From: Sarah Sutcliffe <[REDACTED]>
Sent: 04 April 2022 09:45
To: Simon Davis
Subject: RE: AL/28/22/DOC (Condition 10) & AL/29/22/DOC (Condition 11) (Wing's Nursery, Lidsey Road)

Engineers Comments Regarding Condition 10

SECTION THROUGH HEADWALLS A,B, D AND E
(Scale 1:20)

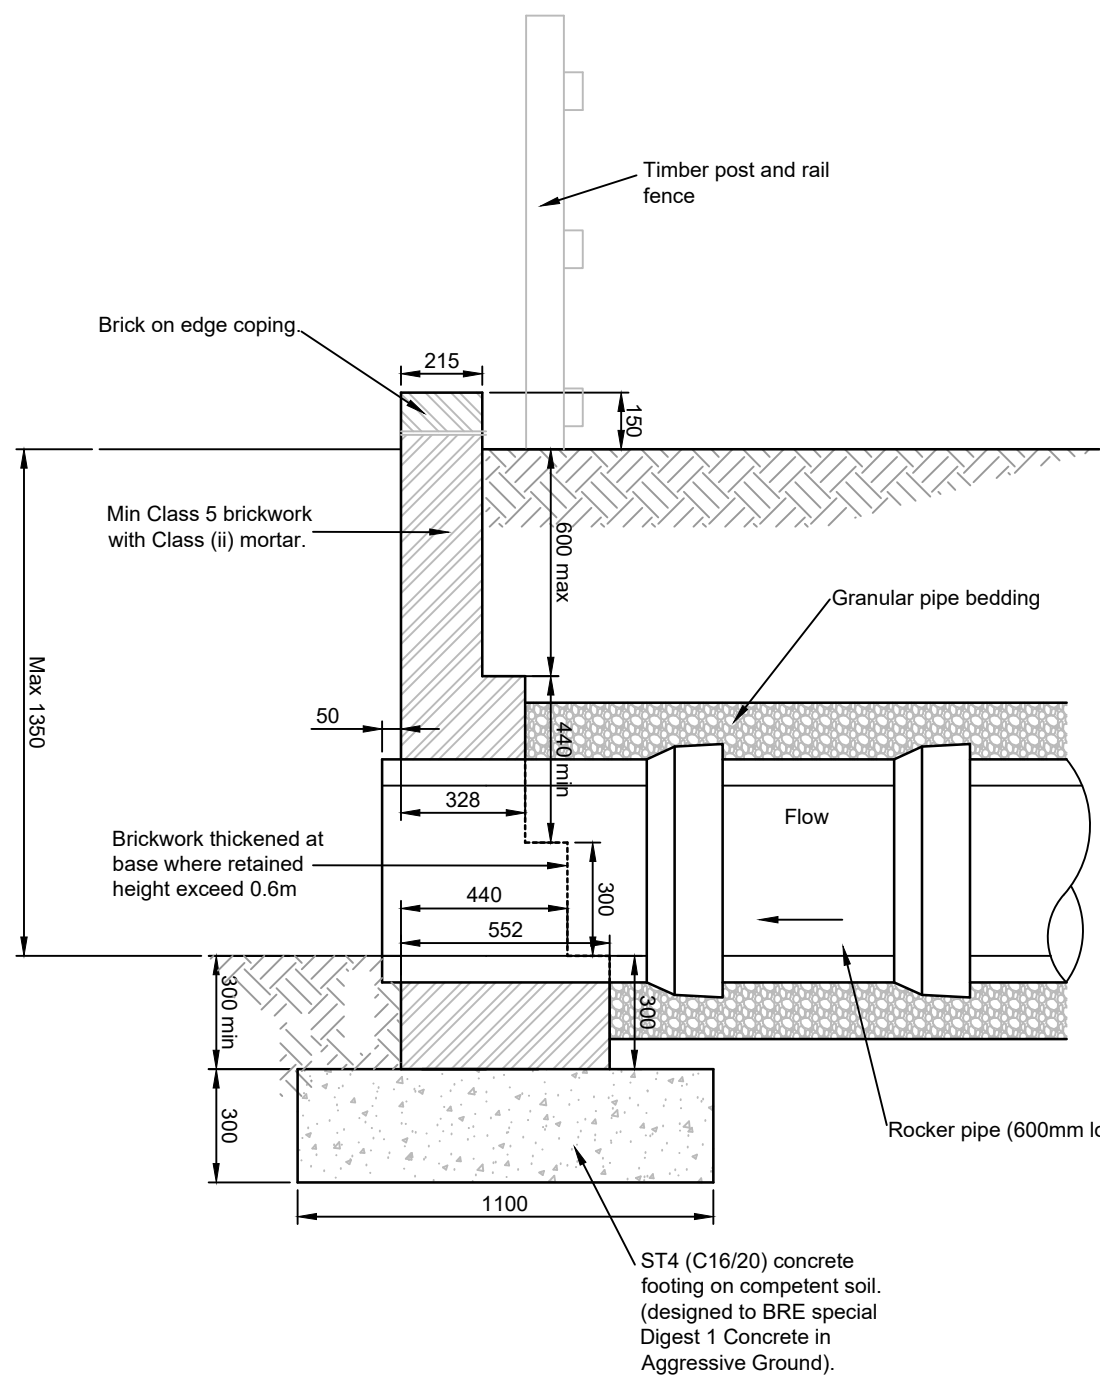
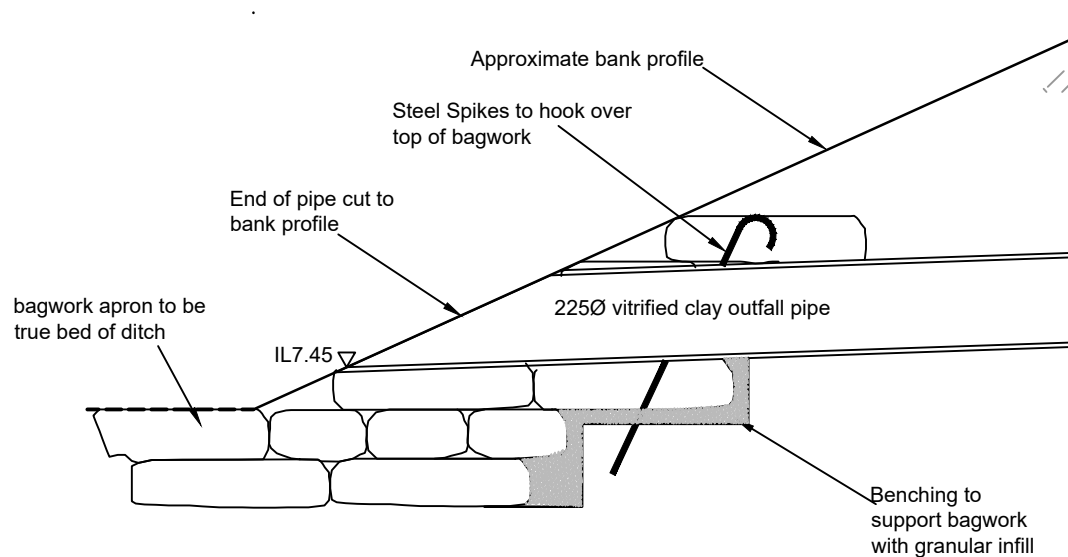
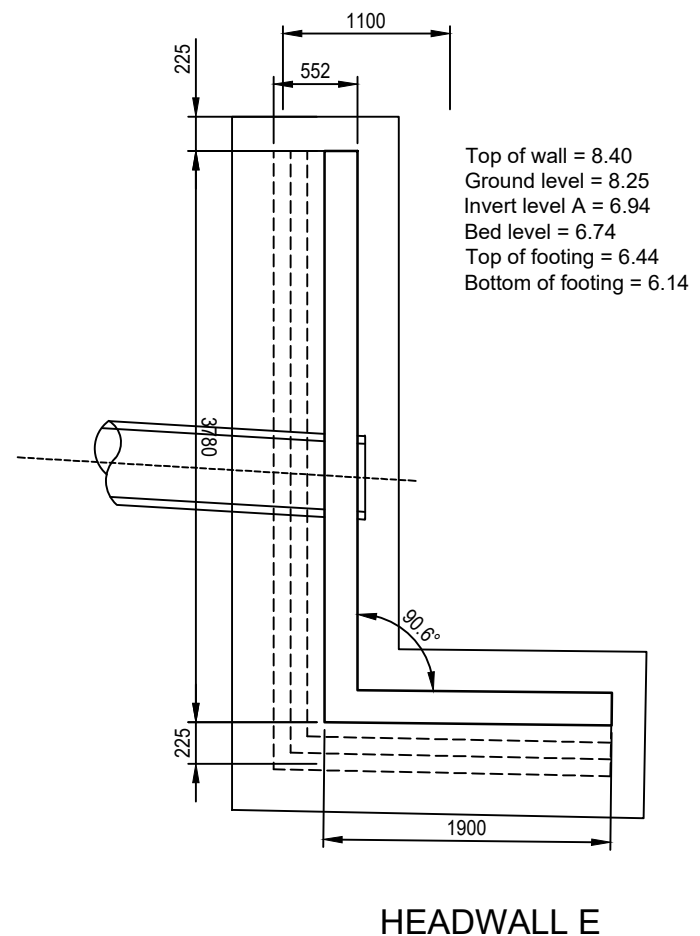
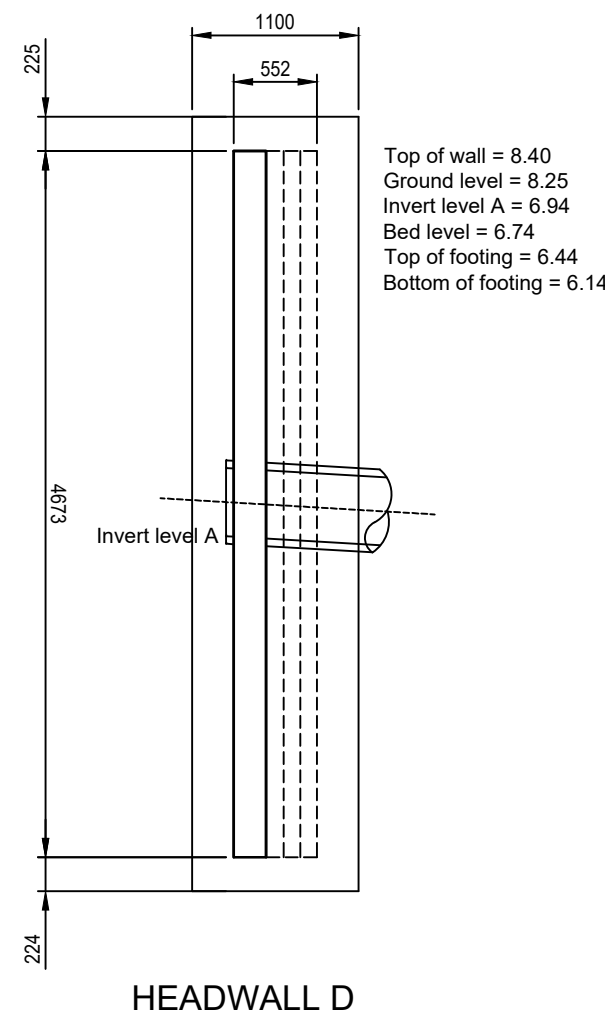
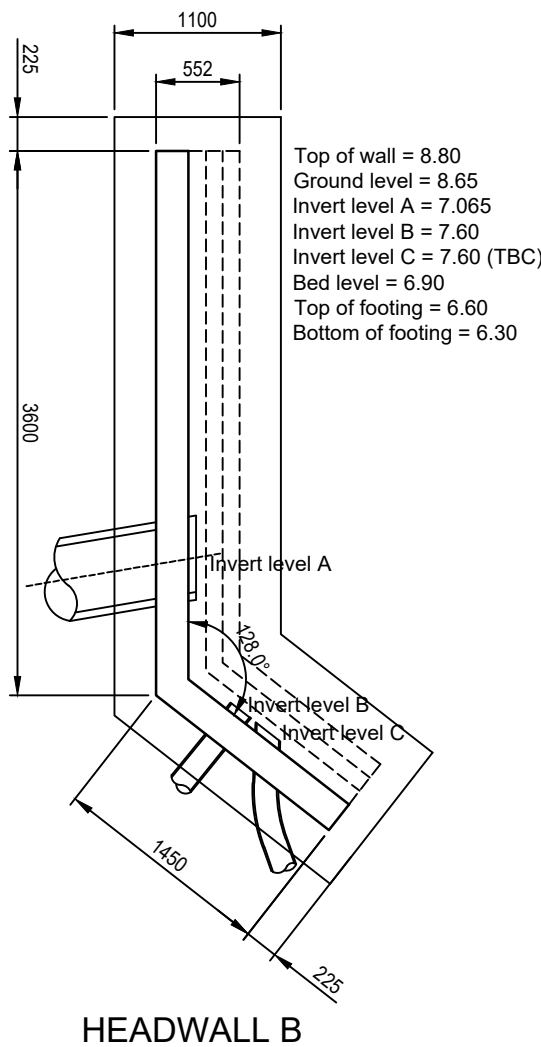
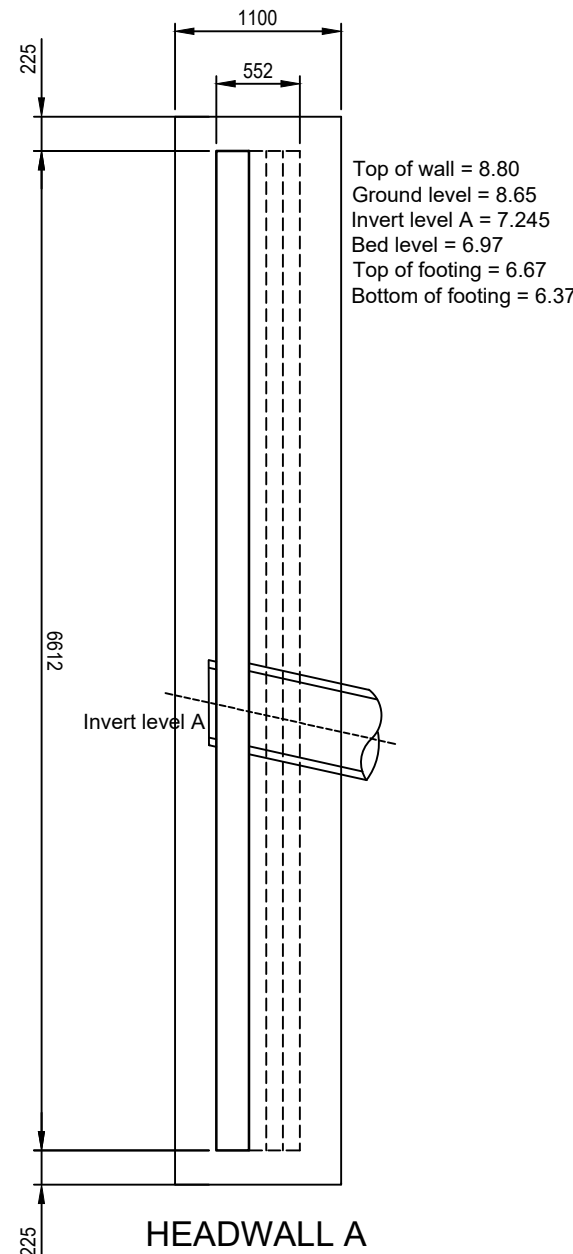
18. *For the bagwork headwalls to the basin- please detail bag size, how full bags are to be with ST4 concrete, how bags are to be compacted, what bond pattern is to be followed, spacing of pins, minimum width of headwalls, etc. Please refer to drawing 15.3.*
